Barangaroo South Building C1 SSD 17_8529

I write on behalf of residents of the Stamford on Kent building at 183 Kent Street Millers Point to raise concerns about this development. Those who have contacted me are concerned about operational and construction noise and vibration impacts.

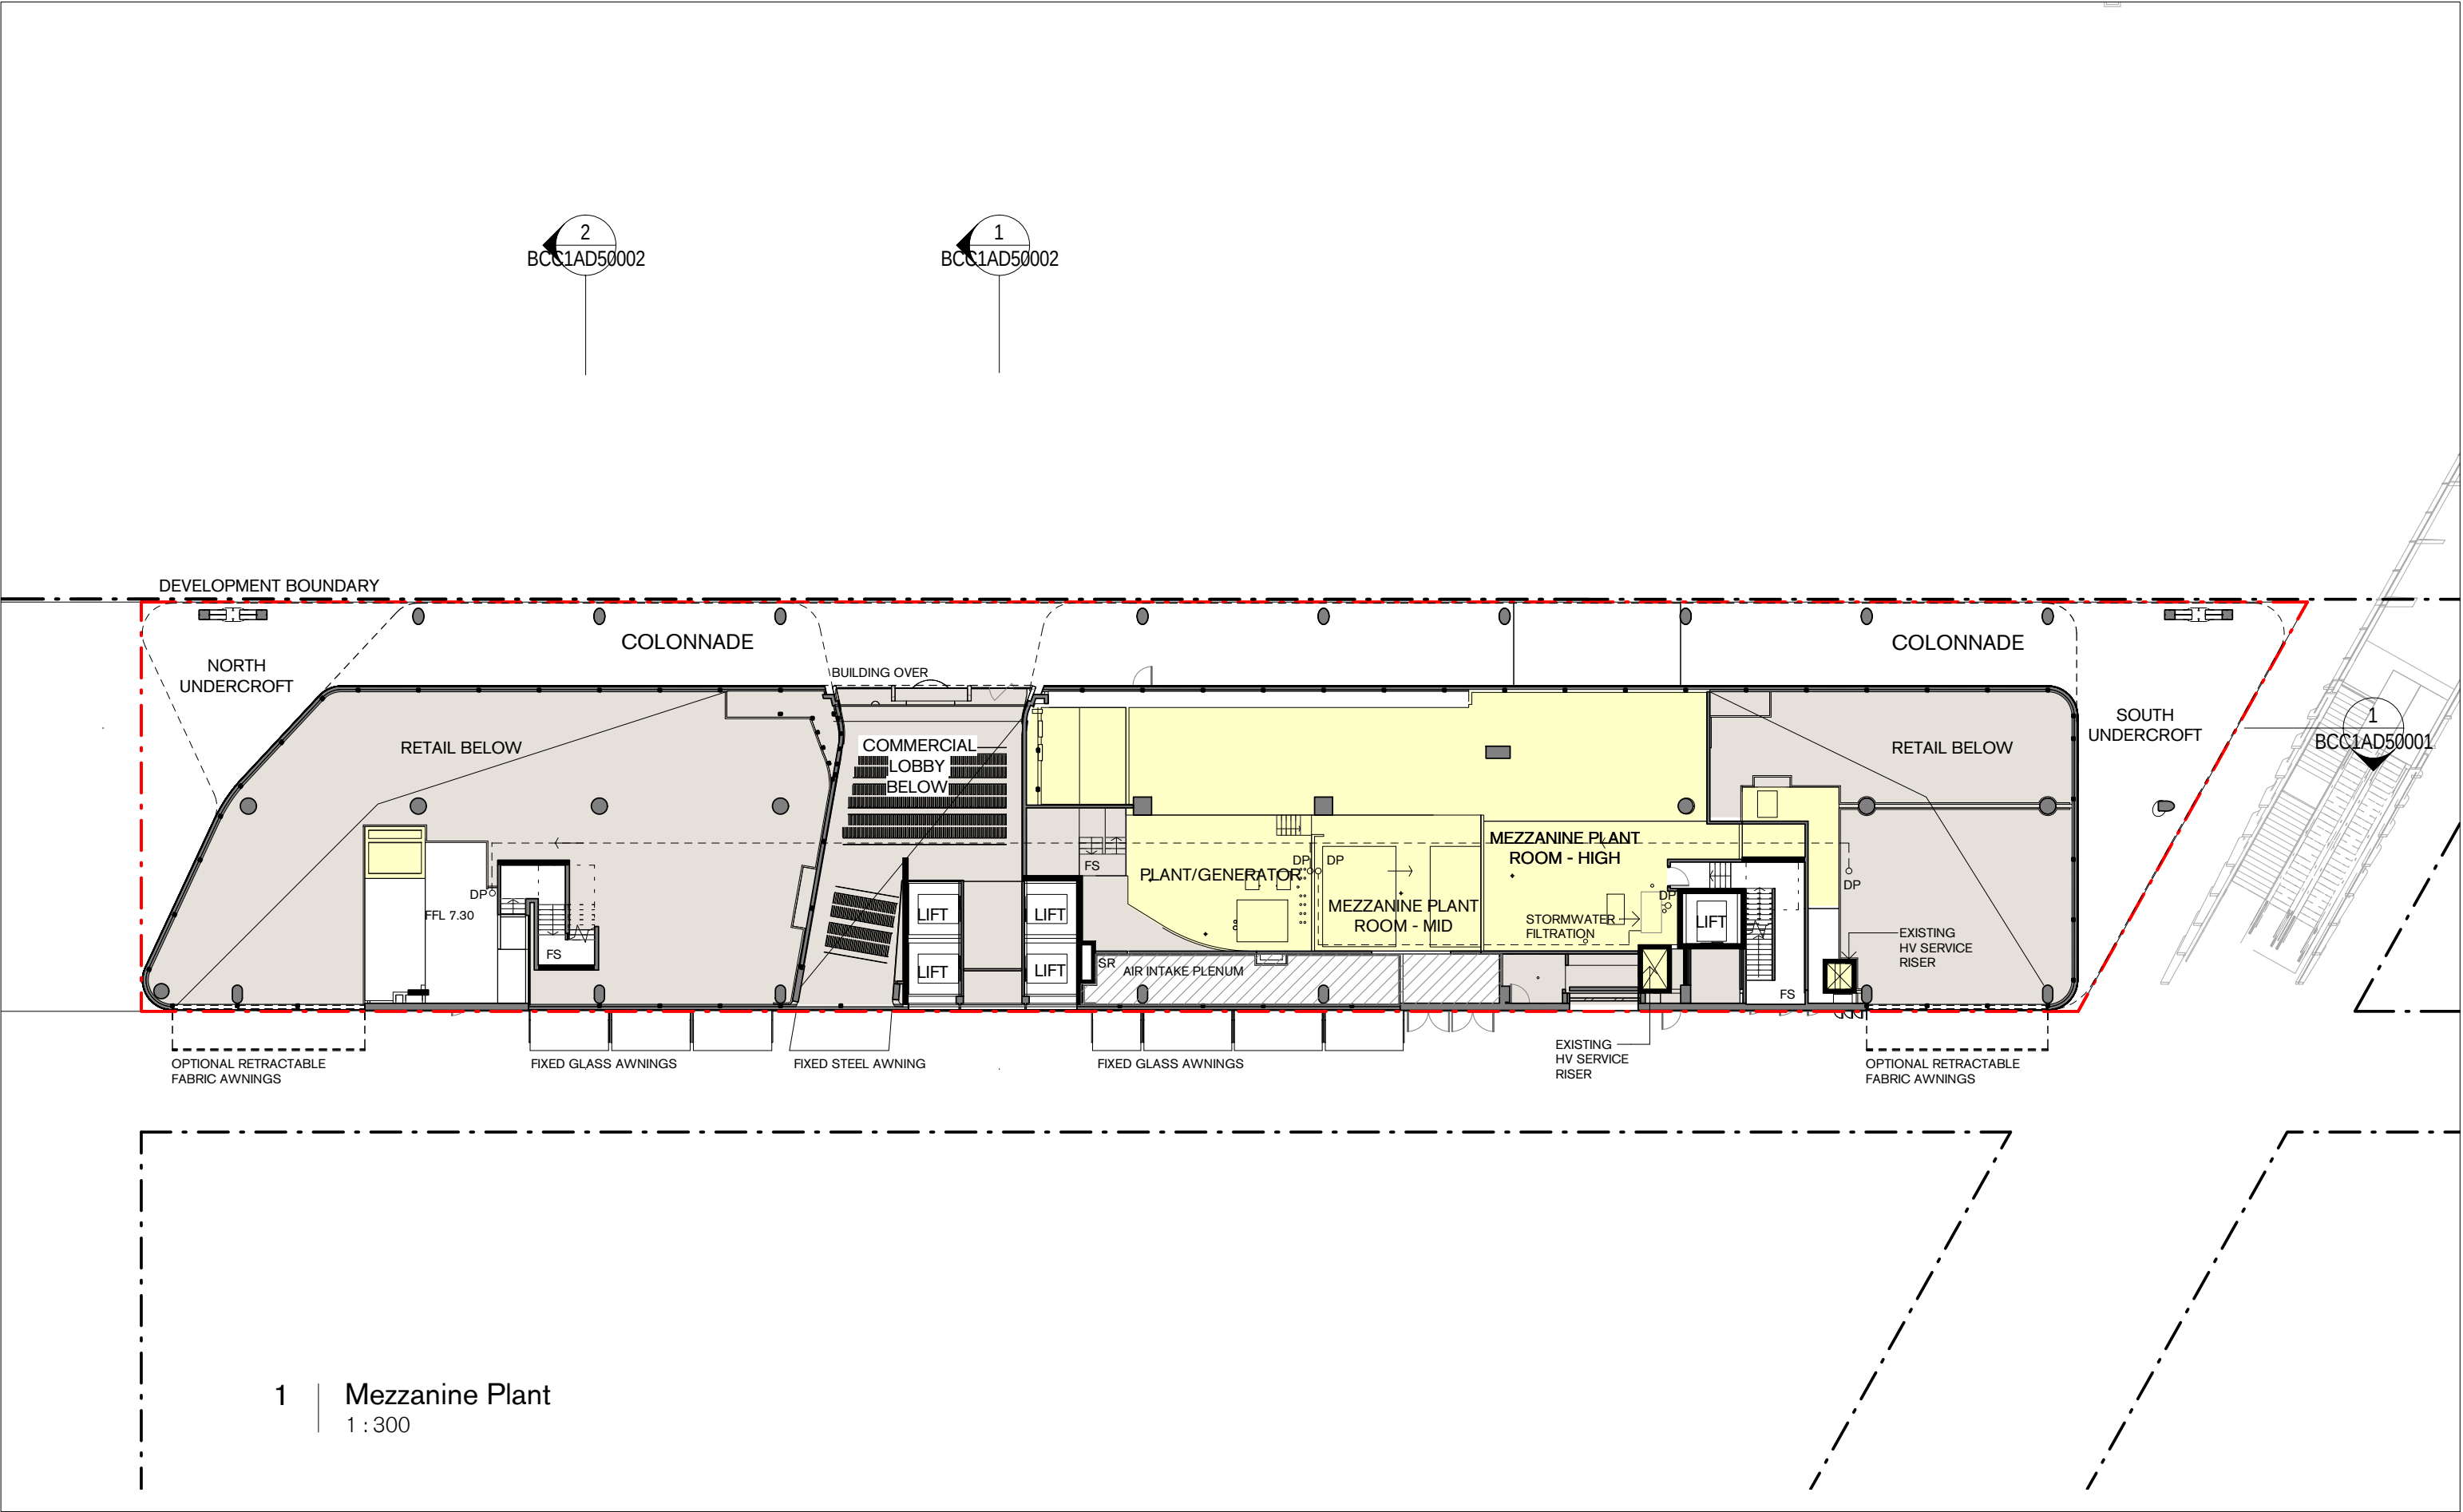
Constituents who have contacted me are concerned about noise impacts from the existing ventilation stacks that will need to be relocated within the proposed building and the mechanical services equipment which will be placed on the building's roof.

It does not appear that operational noise from the mechanical services equipment to be located on the roof has been assessed as residential receivers for homes in the Stamford on Kent despite some apartments likely to be more affected than other residential receivers. Final approval should not be given until expected noise is assessed for the Stamford on Kent and measures are taken to prevent impacts.
